From: Amanda Scholes on behalf of Planning.Responses
Sent: 14 July 2020 11:32
To: Planning Scanning
Subject: FW: D1833: Sunny Corner, Walberton WA/32/20/DOC D1833
Attachments: D1833-007F Construction Details Sheet 3 of 3.pdf; D1833-010B Pond Cross Sections.pdf; D1833-002E Engineering Layout - Below Ground Drainage.pdf; D1833 SW Design 1.2.pdf; D1833 Drainage Maintenance Schedule & Phasing Plan v3.pdf; D1833-001 Engineering Layout - Levels, Contours.pdf; D1833-300 Impermeable Areas Comparison.pdf

From: Laura Gibbons [REDACTED]
Sent: 14 July 2020 10:59
To: Planning.Responses <Planning.Responses@arun.gov.uk>
Cc: Andrew Wood <Andrew.Wood@arun.gov.uk>; Dan Lytton [REDACTED]
Subject: Fwd: D1833: Sunny Corner, Walberton WA/32/20/DOC D1833

The revised information is adequate to address our concerns and condition 8 can be discharged. Please ensure that the following plans are listed on any approval:

From: Laura Gibbons [REDACTED]
Sent: 23 June 2020 09:20
To: Dan Lytton [REDACTED]
Cc: Mark Akmenkalns [REDACTED] Jason Osborn [REDACTED]
Subject: Re: D1833: Sunny Corner, Walberton WA/32/20/DOC D1833

SECTION 1 - LONGSECTION
SCALE: H 1:200,V 1:100. DATUM: 15.000

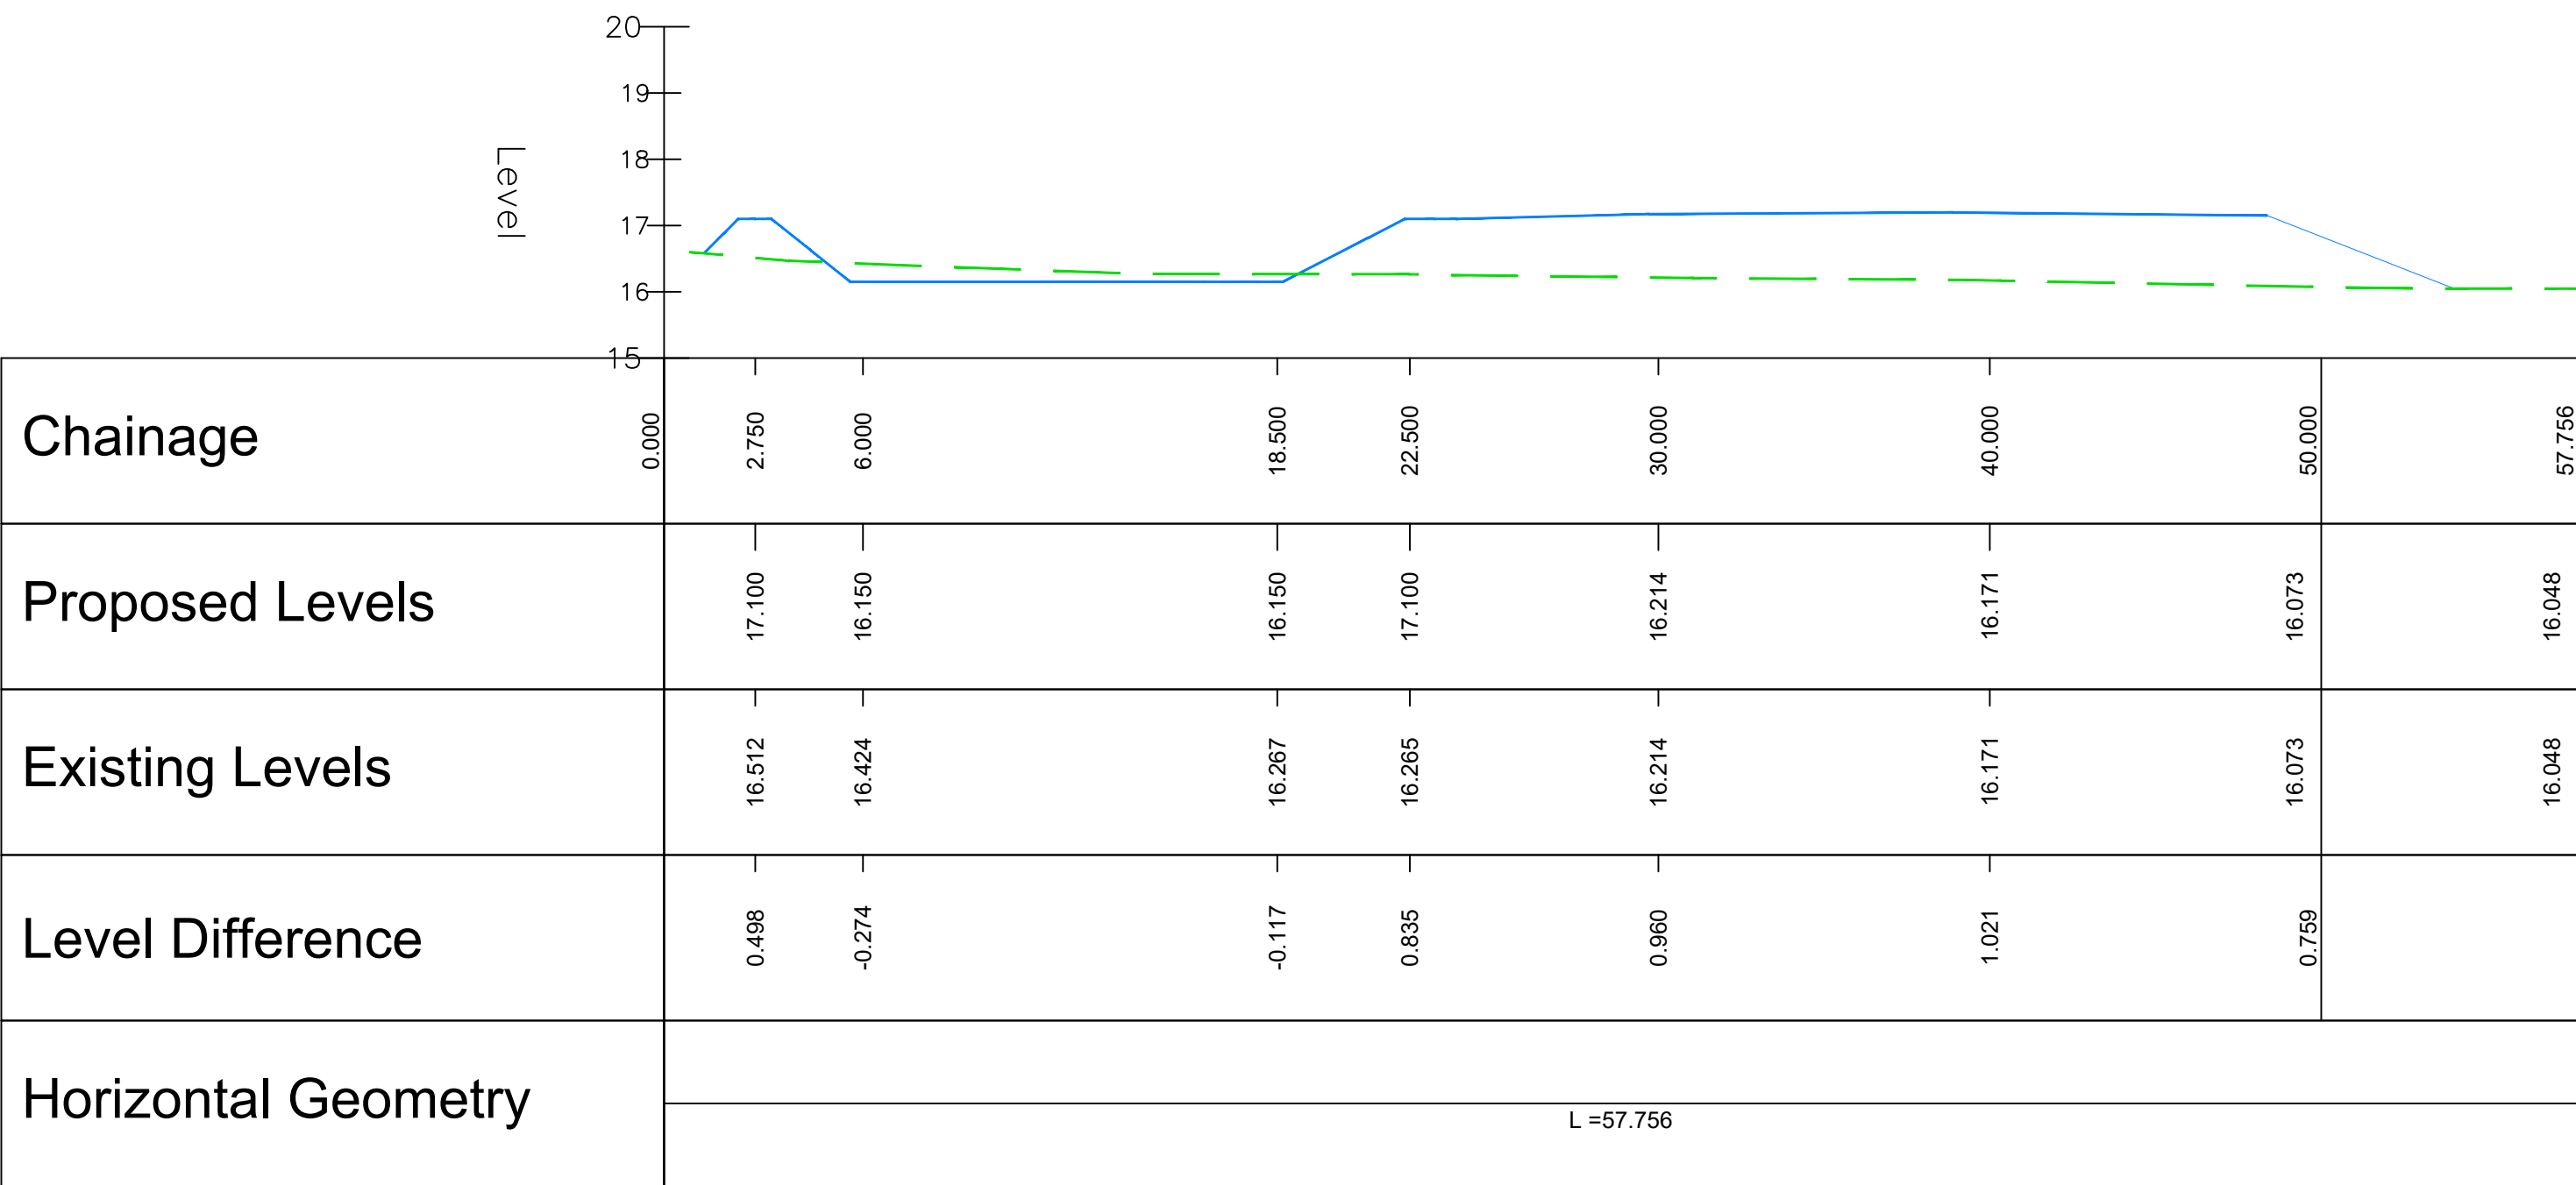
Please ensure that top of bank levels, and base levels of pond are picked up on each cross section. Existing and proposed levels are labelled as being consistent, despite profiles showing change.

9. Done, see updated drawing 010
10. N/A
11. N/A
12. N/A
13. N/A
14. N/A
15. N/A
16. I have included this explicitly within the revised maintenance schedule
17. N/A

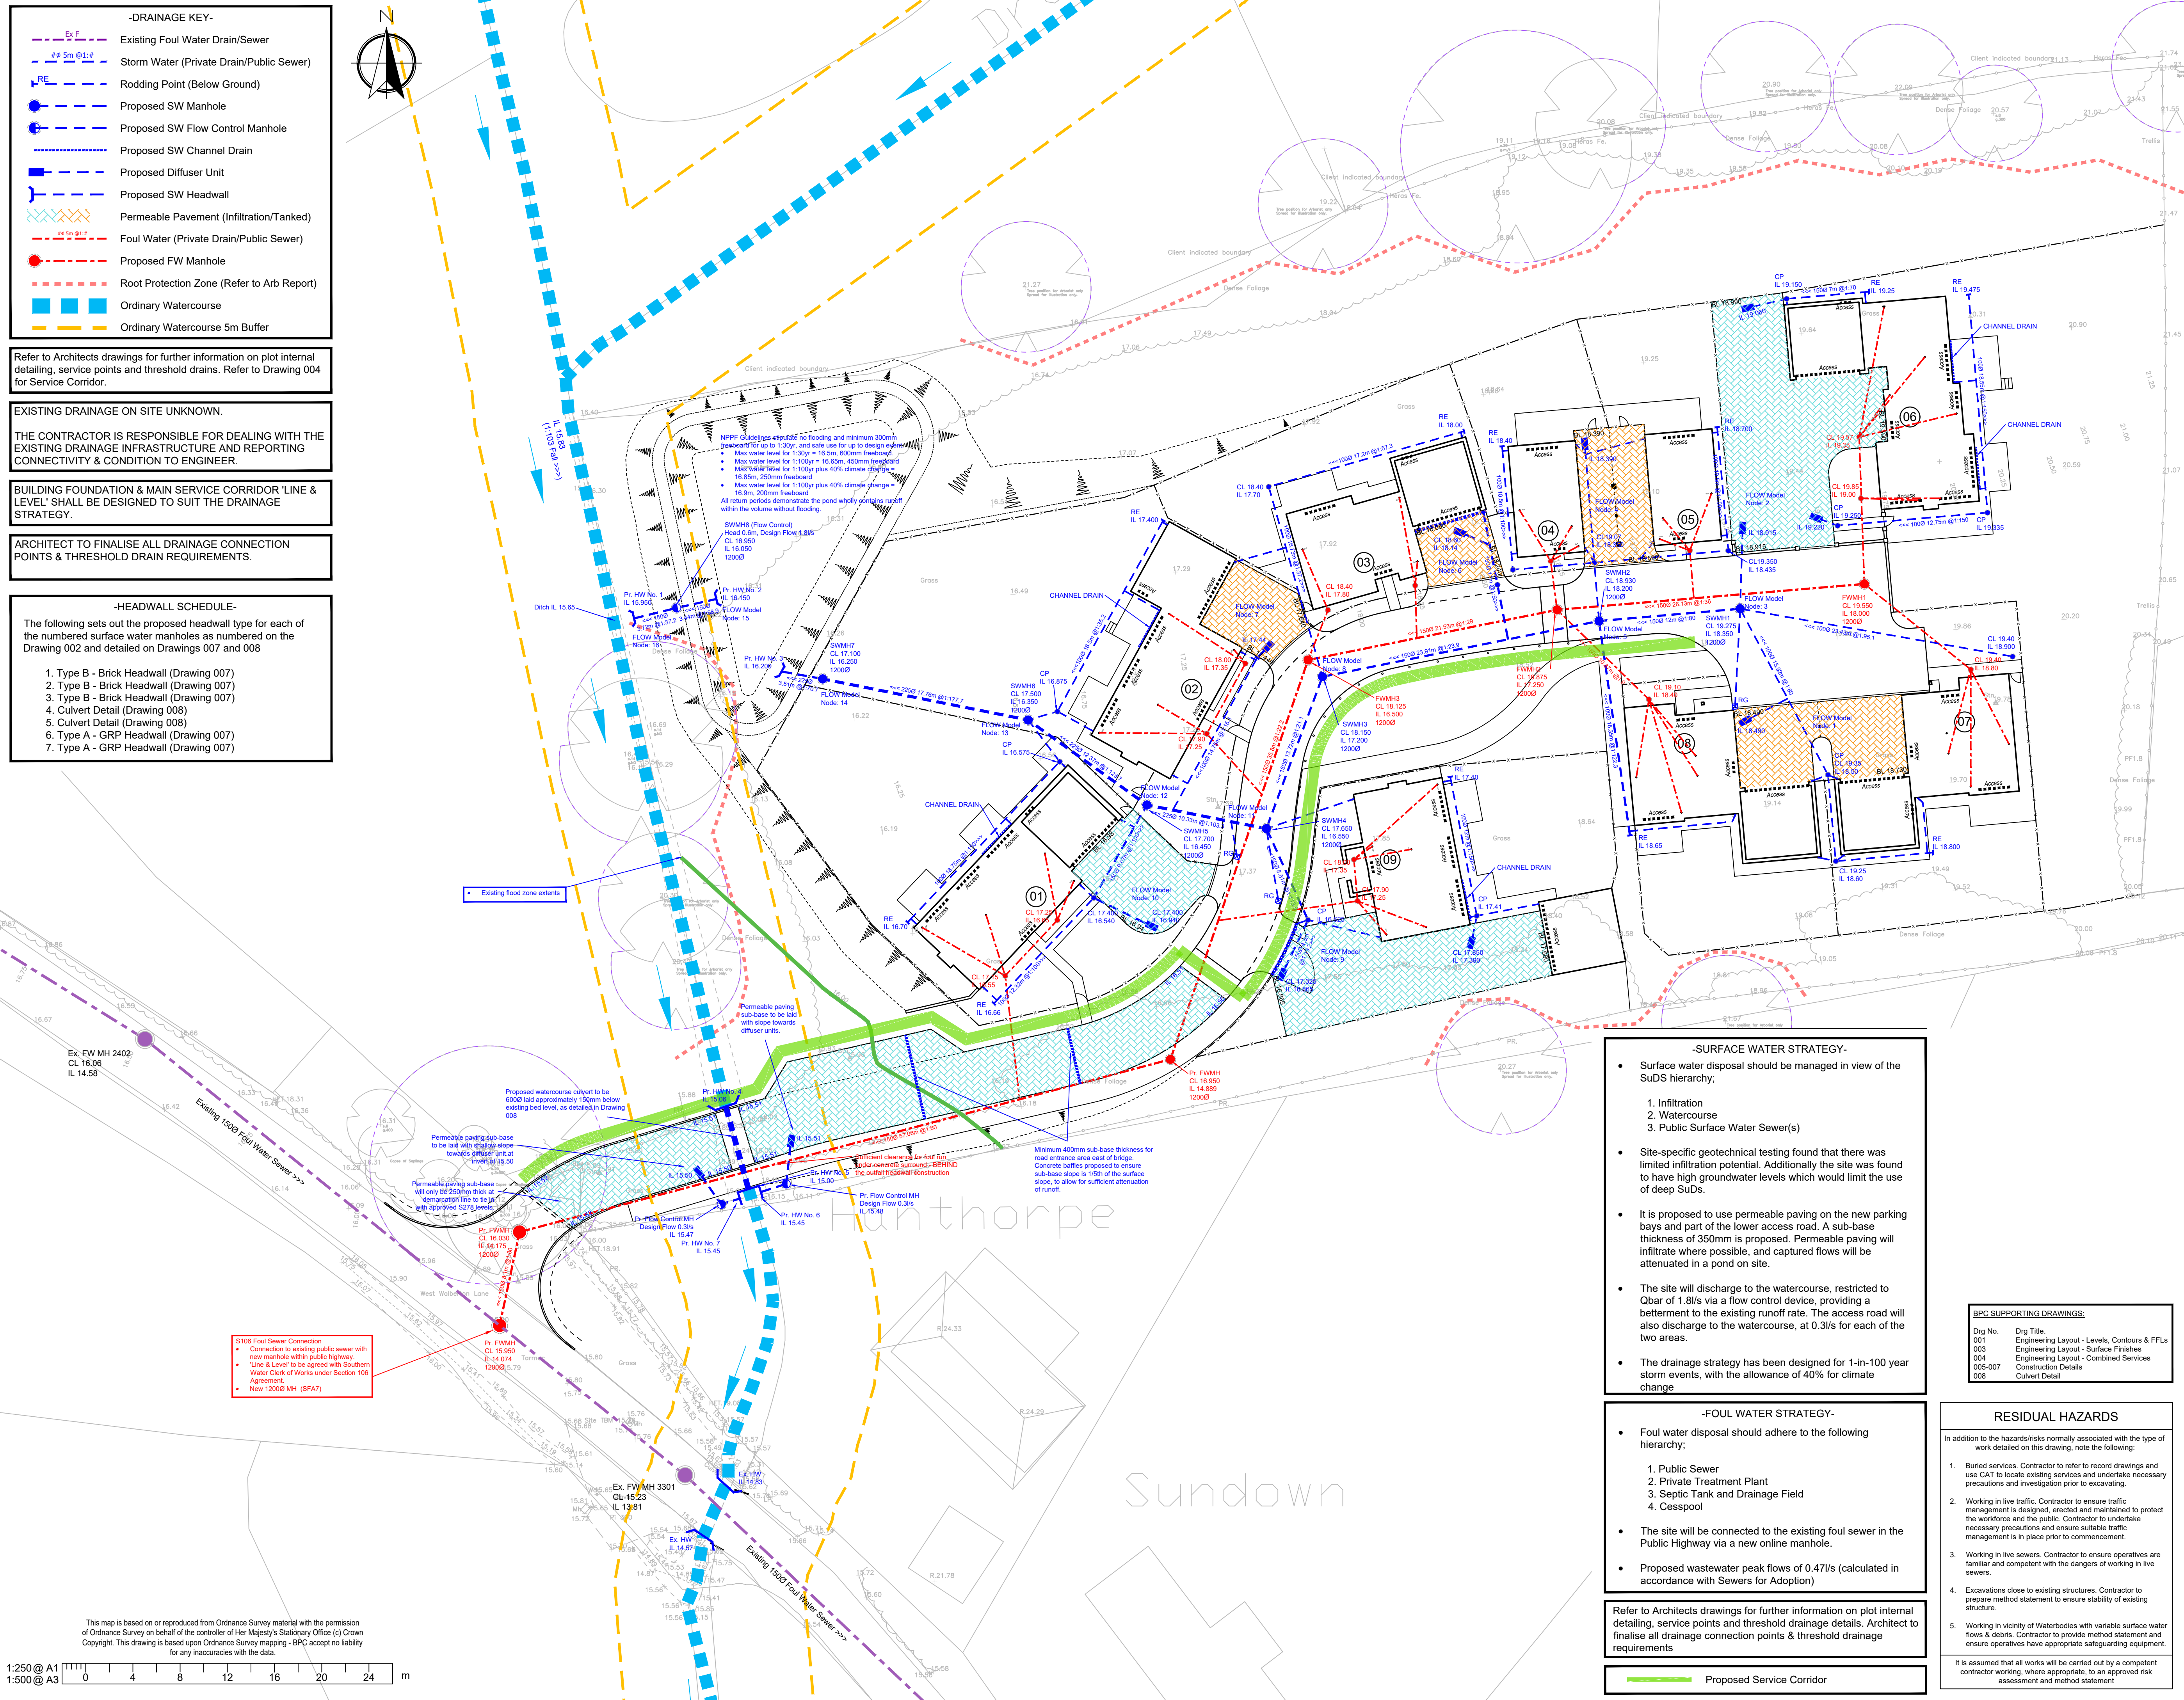
- ✦ *Information provided on drawings does not tally with calculations. Please ensure that finish and formation levels on all permeable paving areas are provided. Please provide invert levels of all diffuser blocks, cover levels at these locations would also be useful.*

- 6. Please include formation and finish levels of permeable paving on surface water drainage drawing.** Please refer to drawing 001 and 006, as well as revised drawing 002. Sub-base invert levels will be laid in accordance with the standard detail other than where explicitly detailed on drawing 002 (entrance road). *Please specify finish and formation levels on surface water drainage drawing. These can be highest and lowest finish and formation levels at each permeable paving block and then further details on levels can be obtained from the other drawings.*

2. The calculations have been updated with correct invert and cover levels, slopes and base levels of permeable paving, and porosity. I have also included base levels of the permeable paving high and low points on the drainage drawing, and as can be seen the sub-base may be more than 350mm thickness in some high points to ensure a slightly flatter slope. The corresponding finish levels are shown on the levels drawing to limit overcrowding and to ensure clarity.

6. The sub-base formation levels shown on dwg 002 whilst finish levels are shown on dwg 001, for clarity.
7. N/A
8. As noted by the expanded point on drawing 002 which we request you refer to as well as the updated calculations, over 300mm freeboard is provided for up to the 100 year event and anything below. For an event of 100 year plus climate change the freeboard is 250mm. All return periods demonstrate the pond wholly contains runoff within the volume without flooding. This is in line with stipulations of NPPF regulations. Please note, in line with our response to Point 1, freeboard for these storm events are likely to be larger due to less runoff reaching the pond. This drawing is updated to reflect accurate levels.
